## NSW RURAL FIRE SERVICE

Your reference: SSD 8859

Our reference: DA-2019-00324-Response to  
Submissions-1

**State Significant Development – Tourist and visitor accommodation  
1111 ELIZABETH DR CECIL PARK NSW 2178, 2/4/DP2954**

Figure 3 Proposed lot design (AE Design Partnership 2020)

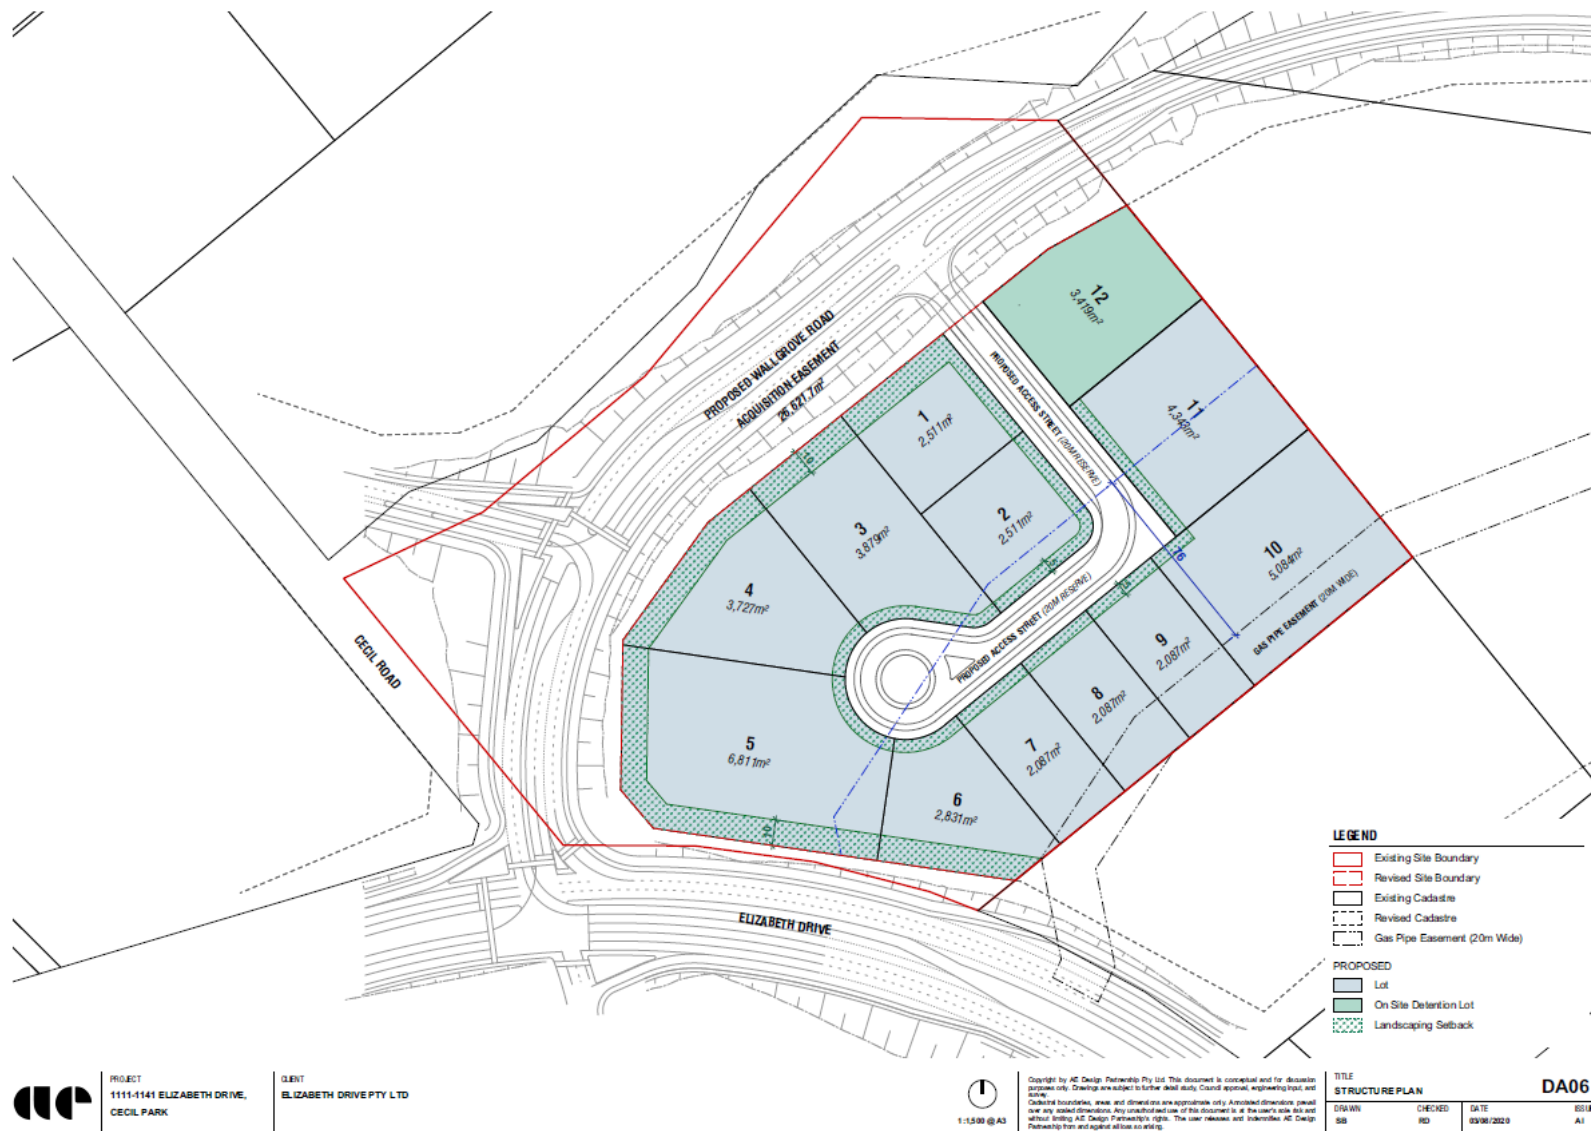
- NSW RFS assessed an effective downslope of 5-10 degrees to the northeast of the development site. As such, an asset protection zone (APZ) of 20 metres along the length of the northeastern boundary of proposed Lots 10 and 11 should be provided to facilitate future commercial-type developments. Otherwise, future buildings will require BAL Flame Zone construction based on the current 12-metre setback, which may not be practicable.

- The subdivision plan is to incorporate a restriction of the use of land under Section 88b of the *Conveyancing Act 1919* to prohibit Special Fire Protection Purpose (SFPP) developments and Class 9 buildings on Lots 6-11 because of APZ constraints as acknowledged in the bush fire report.

- The proposed detention basin on Lot 12 has not been identified as potential hazard despite connectivity to Grassy Woodland vegetation the northeast. As such, a suitable mechanism is to be proposed ensuring the ongoing management of the basin by a body corporate under a Community Title Scheme or a Plan of Management by a government entity. Otherwise, the potential bush fire threat must be addressed, including how it impacts on the single point access for future SFPP developments.
